Norfolk Boreas Offshore Wind Farm Schedule of Changes to the draft Development Consent Order (Version 8)

Applicant: Norfolk Boreas Limited
Document Reference: ExA.SCh.D18.V8
Deadline 18

Date: October 2020
Revision: Version 8
Author: Womble Bond Dickinson

Schedule of Changes to the draft DCO

Requirement 16 (5)
Buildings must not exceed 19m

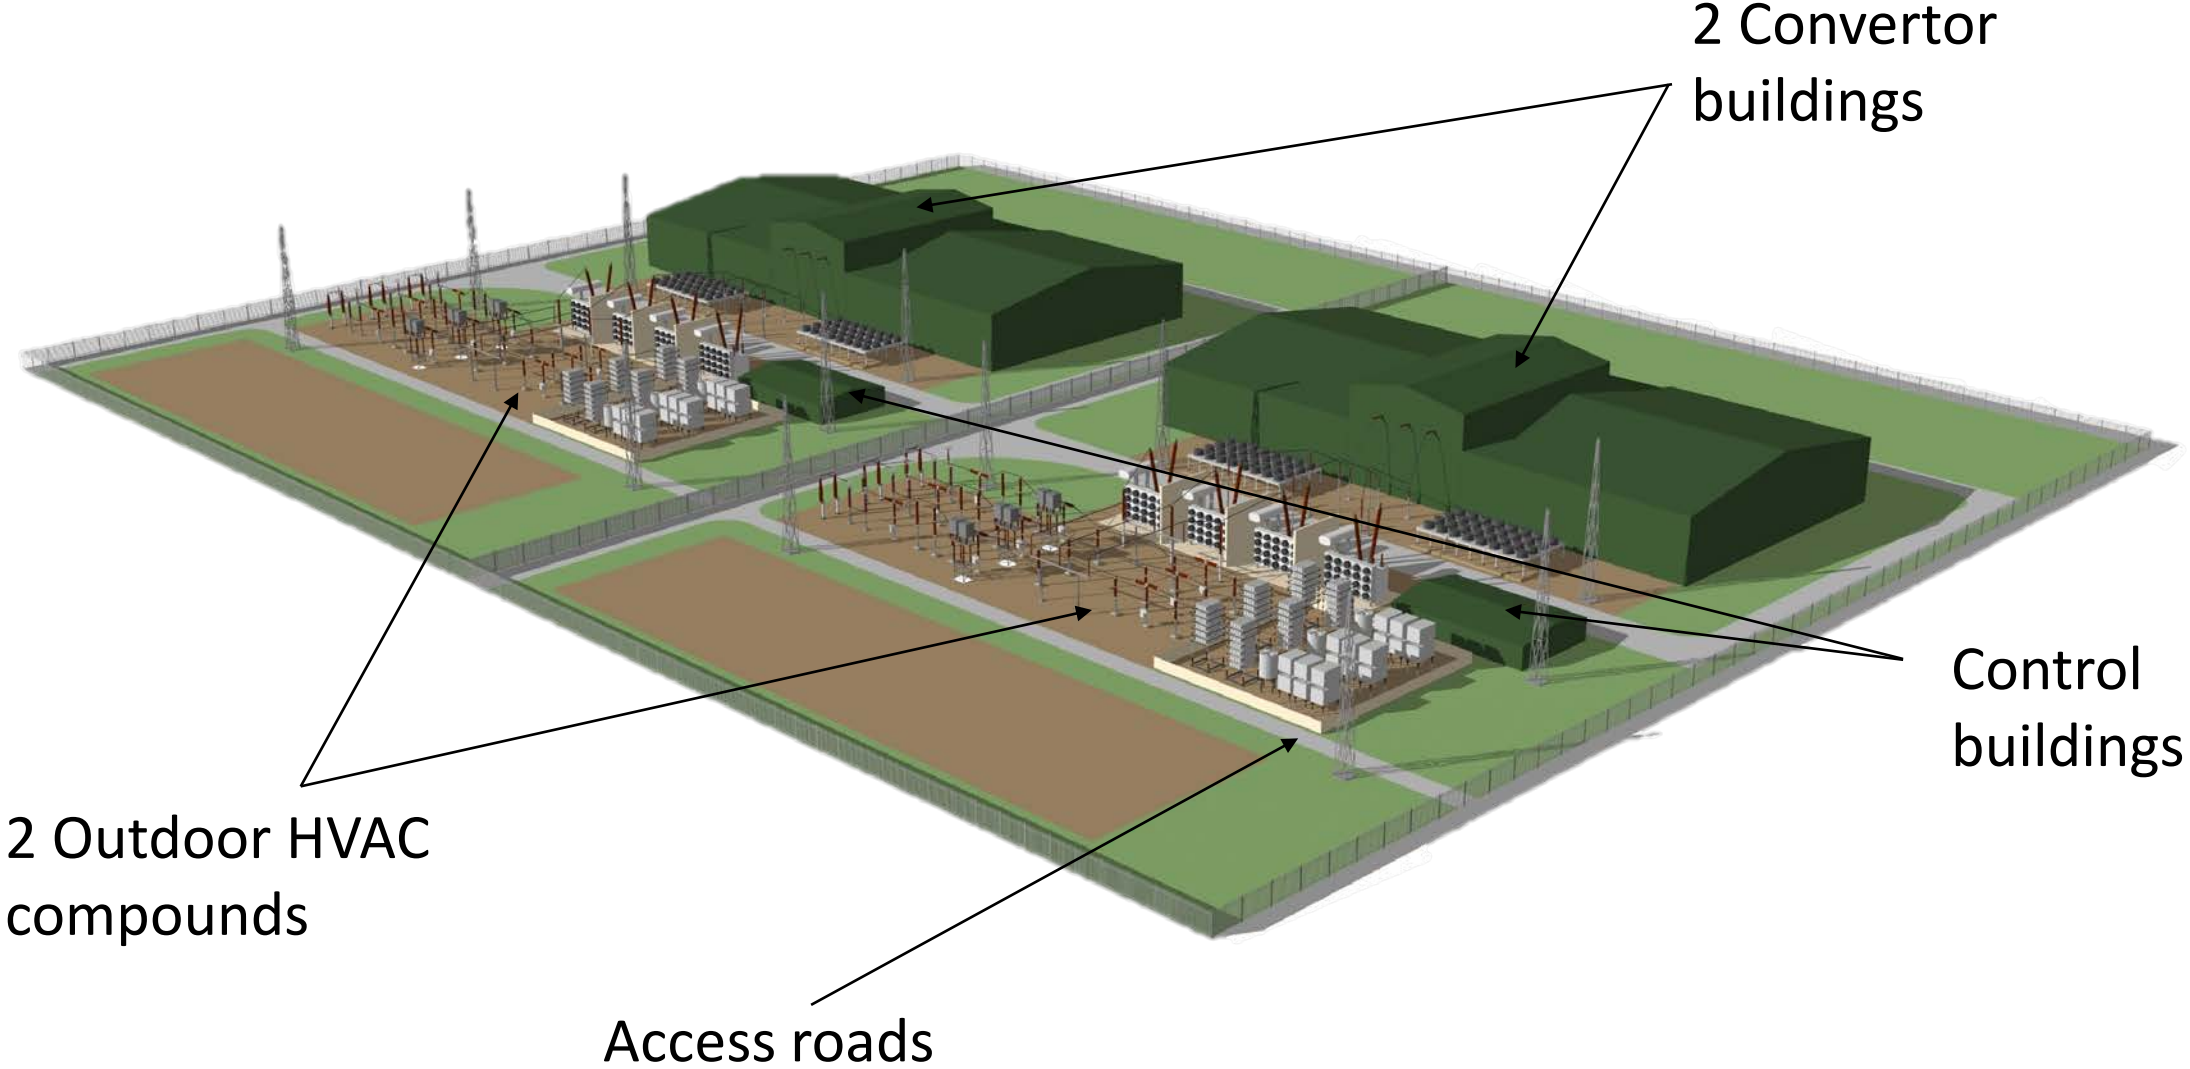
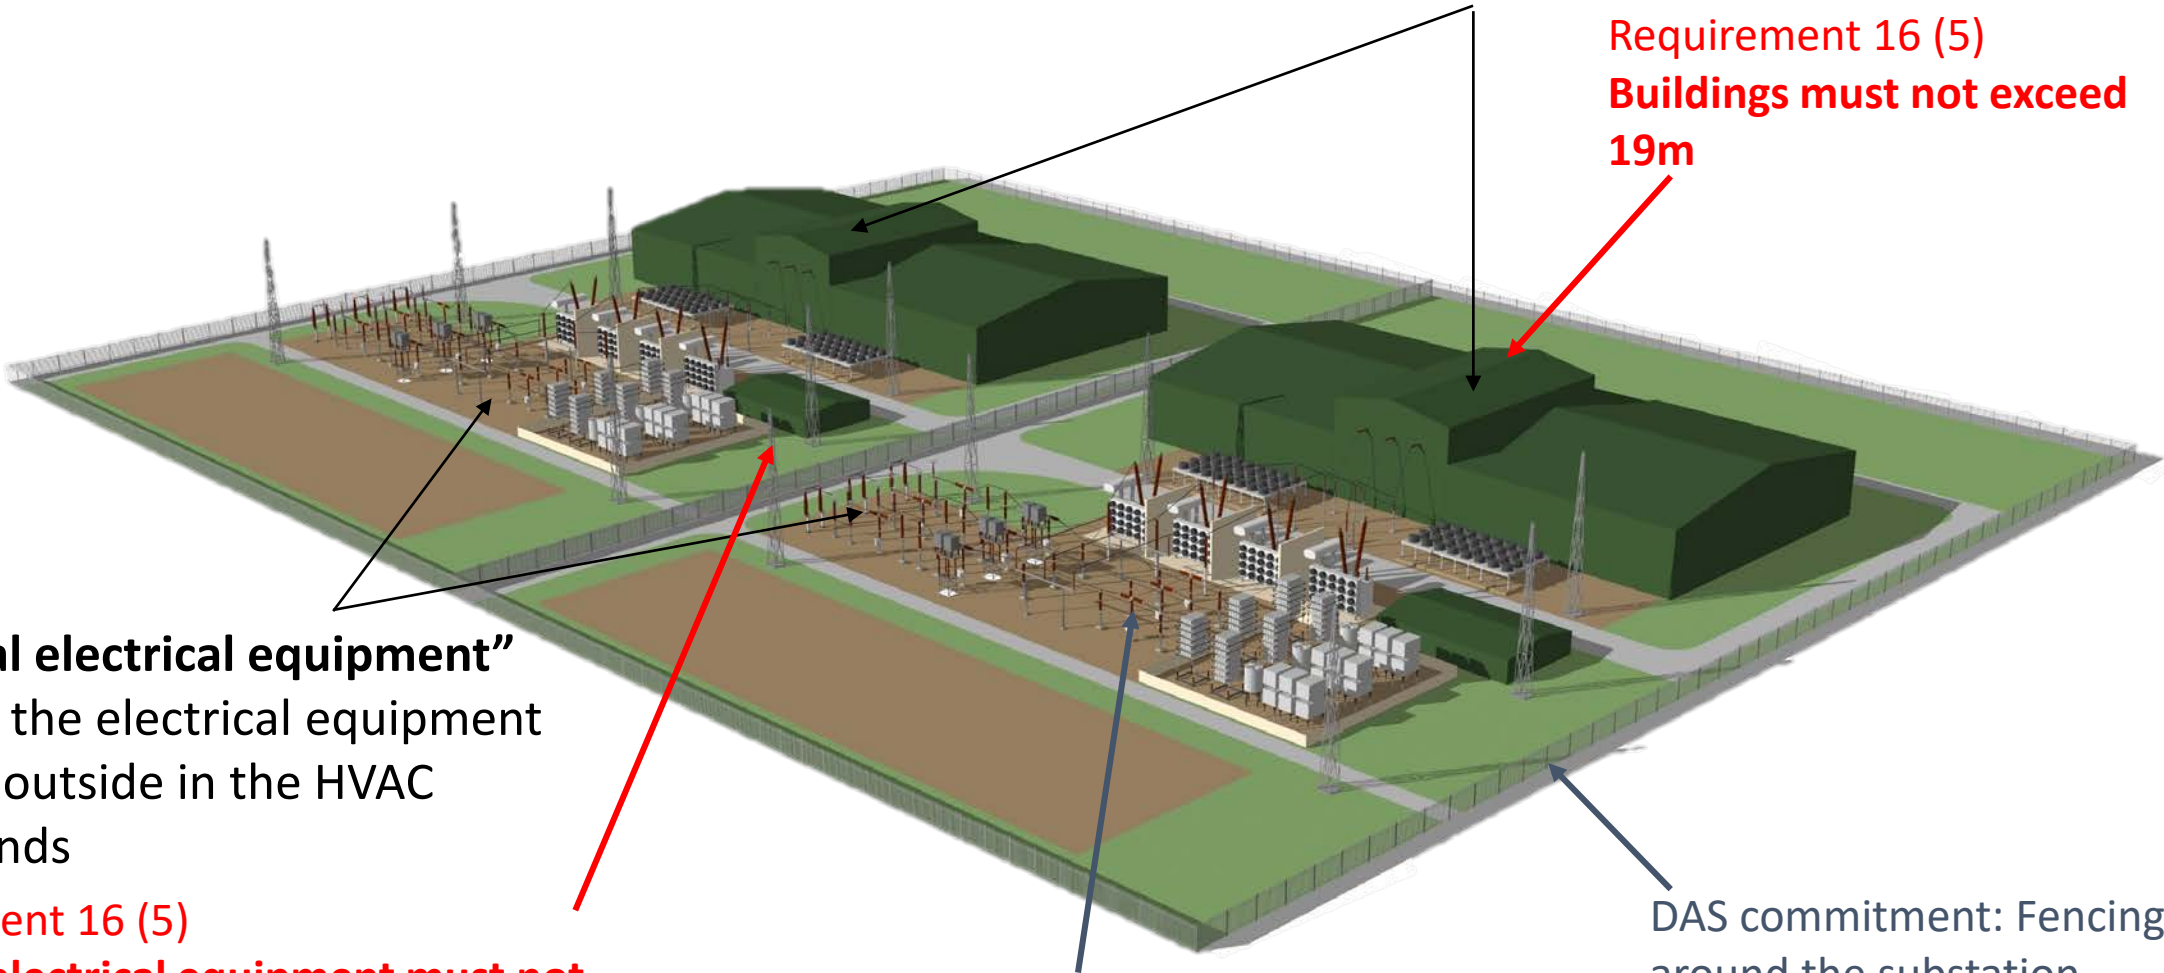
48.	Requirement 16	ExA	At the hearing into onshore matters held on 21 January 2020, the ExA asked for clarity on the buildings housing the principal electrical equipment. The Applicant has therefore inserted a new definition for converter building at Article 2 and referred to converter building(s) in Requirement 16.	16.—(1) <i>The total number of converter buildings housing the principal electrical equipment for the onshore project substation comprised in Work No. 8A must not exceed two.</i> (2) <i>Construction works for the onshore project substation buildings referred to in paragraph (1) above must not commence until details of the layout, scale and external appearance of the same have been submitted to and approved by the relevant planning authority.</i> ... (5) <i>Buildings (including the converter buildings) comprised in Work No. 8A must</i>	4

<p>not exceed a height of 19 metres above existing ground level and external electrical equipment comprised in Work No. 8A must not exceed a height of 25 metres above existing ground level.</p> <p>(6) The total footprint of each <i>converter building housing the principal electrical equipment for the onshore project substation comprised in Work No. 8A</i> must not exceed 110 metres by 70 metres.</p>
